# One Earth Solar Farm

**Draft Statement of Common Ground with the Environment  
Agency**

**EN010159/APP/8.11.24**

~~Octo~~August ~~September~~November 2025

Appendix B Example Trenchless Crossing Cross-Sections

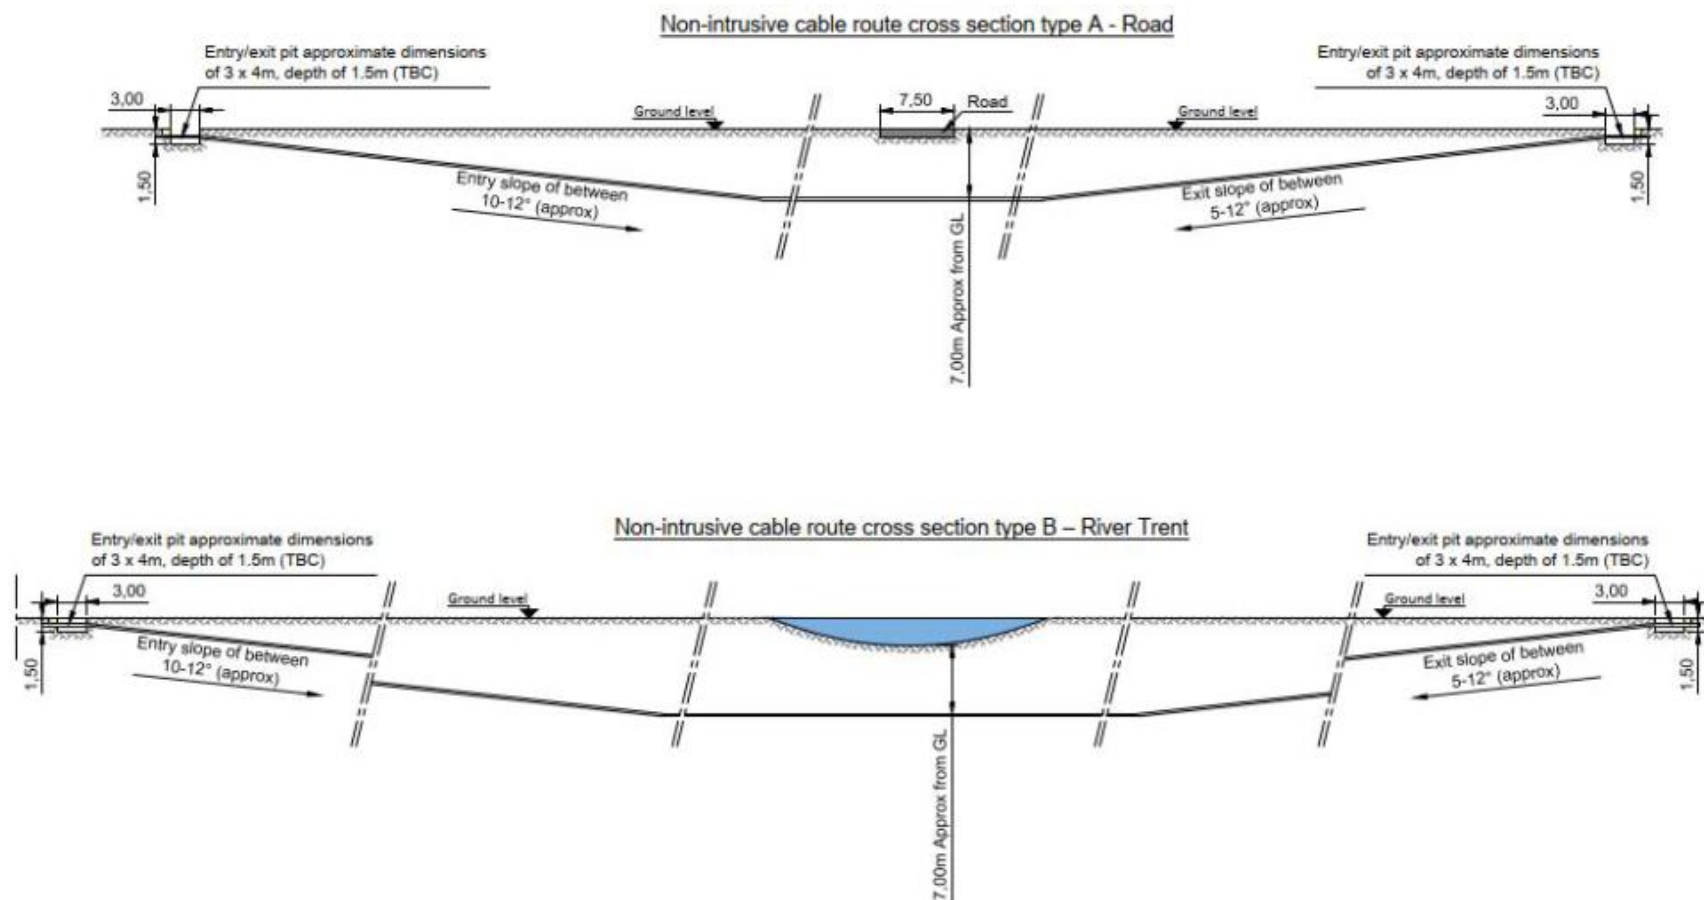
Applicant to consider the impacts of cable crossings beneath Main Rivers and existing flood defences.

The proposed cable crossing beneath the River Trent will be undertaken using trenchless techniques and specific construction processes will be set out within the CEMP.

A hydromorphology survey, river bed survey and hydrogeological risk assessment to be undertaken to inform the design of the cable crossing beneath the River Trent.

Surveys of the existing flood defences will be undertaken at detailed design if deemed required. Furthermore, monitoring of the flood defences can also be undertaken during construction if deemed necessary.

Figure 3.3 Suitable Habitat for Otter and Water Vole

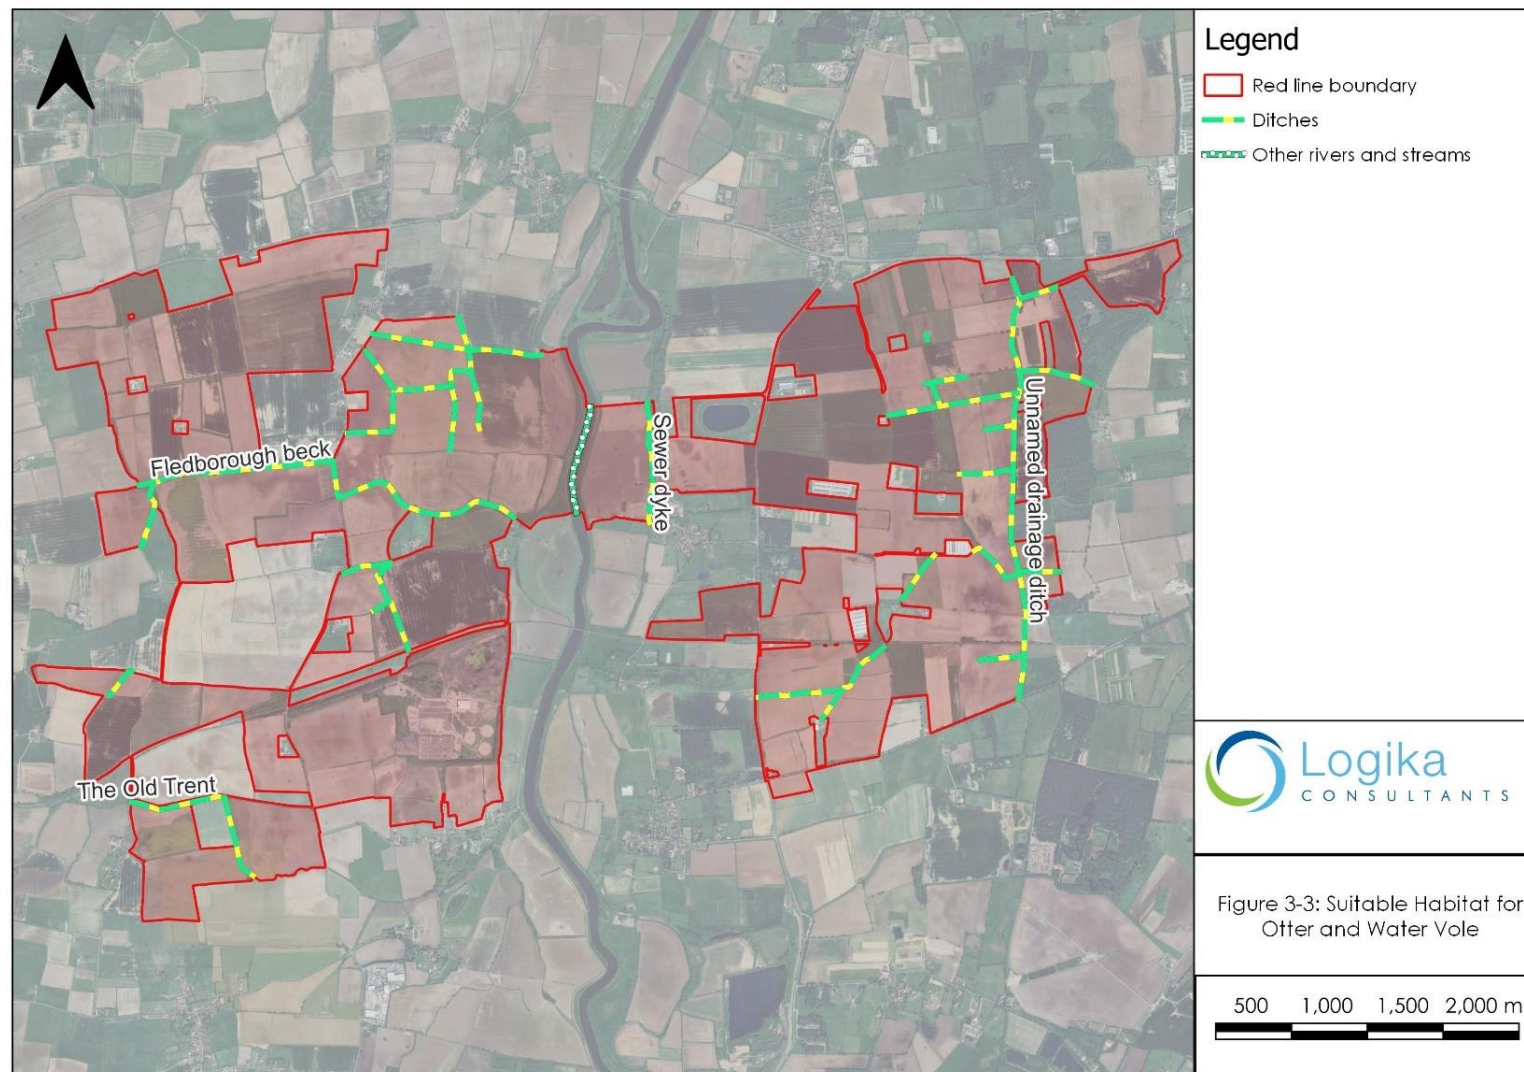
EA raises concerns around the adequacy of protected mammal surveys.

The otter and water vole survey described in Appendix 6.7 Badger, Otter and Water Vole Baseline [APP-090] provides sufficient information on otters and water vole distribution to undertake a robust assessment of the effects of the proposed development on these species. This is in light of the mitigation measures integrated within the project design.

It is noted that the timing of surveys for water vole were appropriate in line with prevailing weather conditions and the Water Vole Mitigation Handbook.
